City of Albuquerque Stormwater Construction Site Inspection Report

ESC File No.	B18E029	Project Name:	The Peaks by Markana Ph 2		
NPDES Id. No.	NMR1004QW	Location:	6700 Modesto Avenue NE		
6/29/2022	Owner	Contractor			
Operator	KLA 9, LLC.	Kasam Construction			
Contact name & title	Faizel Kassam	Stephen Pendergraft			
e-mail	fkassam@legacy-hospitality.com	Spendergraft@Legacydm.net			
Contact Phone #	505-489-4474	720-7188			
COA Inspector	Doug Hughes	Start/End Time:	2:00 AM		
Construction Phase:	Staging				
Type of Inspection:	<input checked="" type="checkbox"/> Regular	<input type="checkbox"/> Storm Event	<input type="checkbox"/> Past Storm Event >0.25"	<input type="checkbox"/> 311/Complaint	<input type="checkbox"/> Follow Up
Weather at time of inspection?		Clear		Temperature: ~	94
Estimated date of last storm 0.25" or greater		6/27/2022

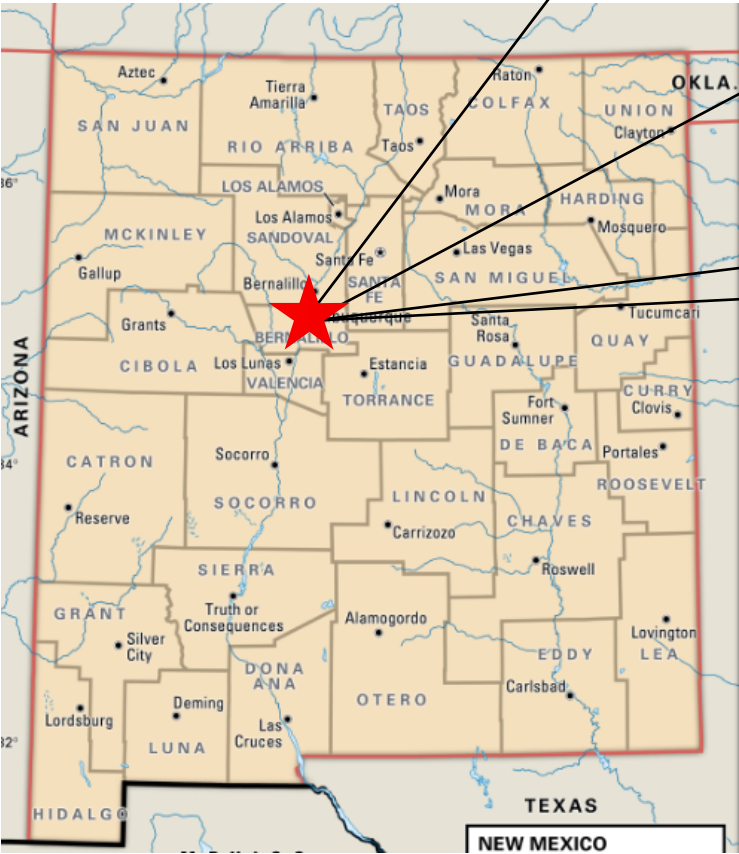
Item Number	Deficiency/ Corrective Action				
1	SWPPP was up-to-date and available, Posting was being put up by Stephen, BMP instalation was nearly complete. So previous violations were mitigated.				
2	The SWPPP map needs updated with current conditions showing mulch sock instead of silt fence, and area of disturbance south of site on City property. Also show the planned trail connection and easement to Phase 1 and add landscaping stabilization to offsite disturbed areas.				
3	Please provide a copy of the latest self-inspection report.				
4					
2.1	Discharge off site? (Y/N)	no			
4	Self Inspection Reports	Requested	Latest report Date:	n/a
